**EL PASO COUNTY PLANNING AND  
 COMMUNITY DEVELOPMENT  
 DEPARTMENT**

**STORMWATER MANAGEMENT PLAN CHECKLIST**

Revised: July 2019

SITE GRADING & EROSION CONTROL PLAN

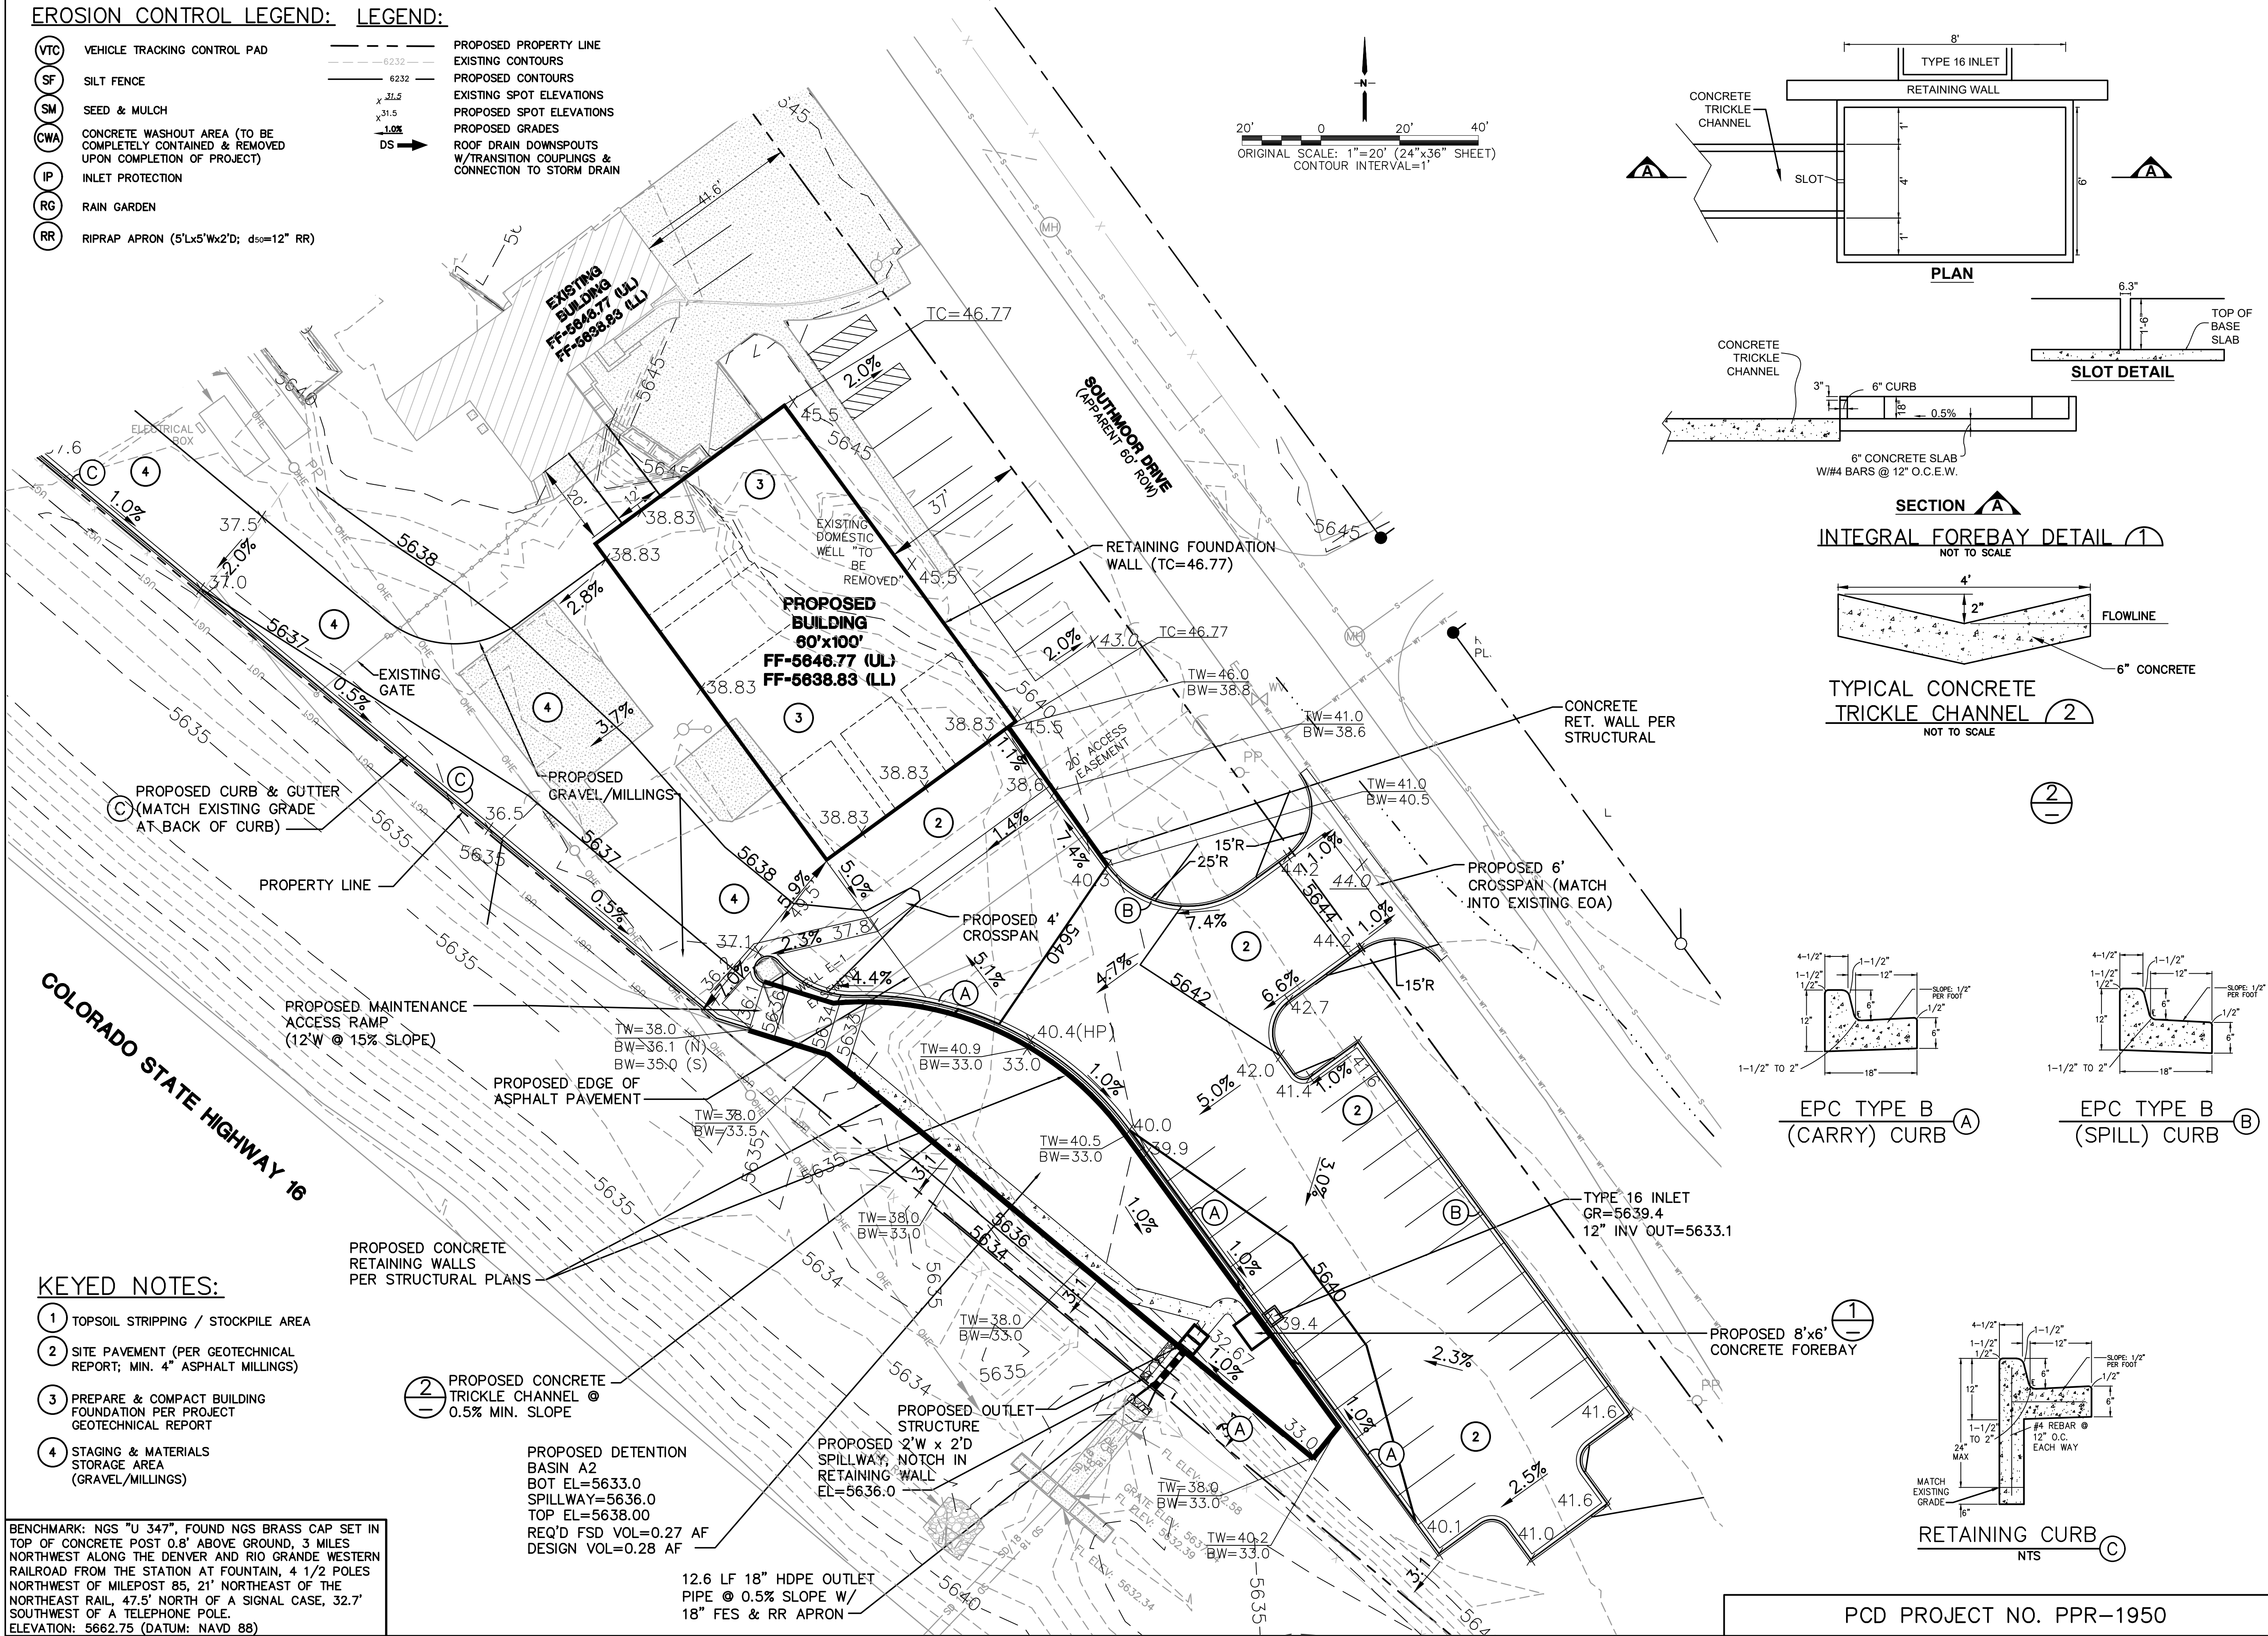
|  |  | Applicant | PCD |
|--|--|-----------|-----|
| 17a  | construction site boundaries   | Y         | X   |
| 17b  | flow arrows to depict stormwater flow directions   | Y         | X   |
| 17d  | areas of cut and fill  | Y         | X   |
| 17e  | areas used for storage of building materials, soils (stockpiles) or wastes   | Y         | X   |
| 17g  | location of all structural control measures  | Y         | X   |
| 17h  | location of all non-structural control measures  | Y         | X   |
| 17i  | springs, streams, wetlands and other surface waters, including areas that require maintenance of pre-existing vegetation within 50 feet of a receiving water   | Y         | X   |
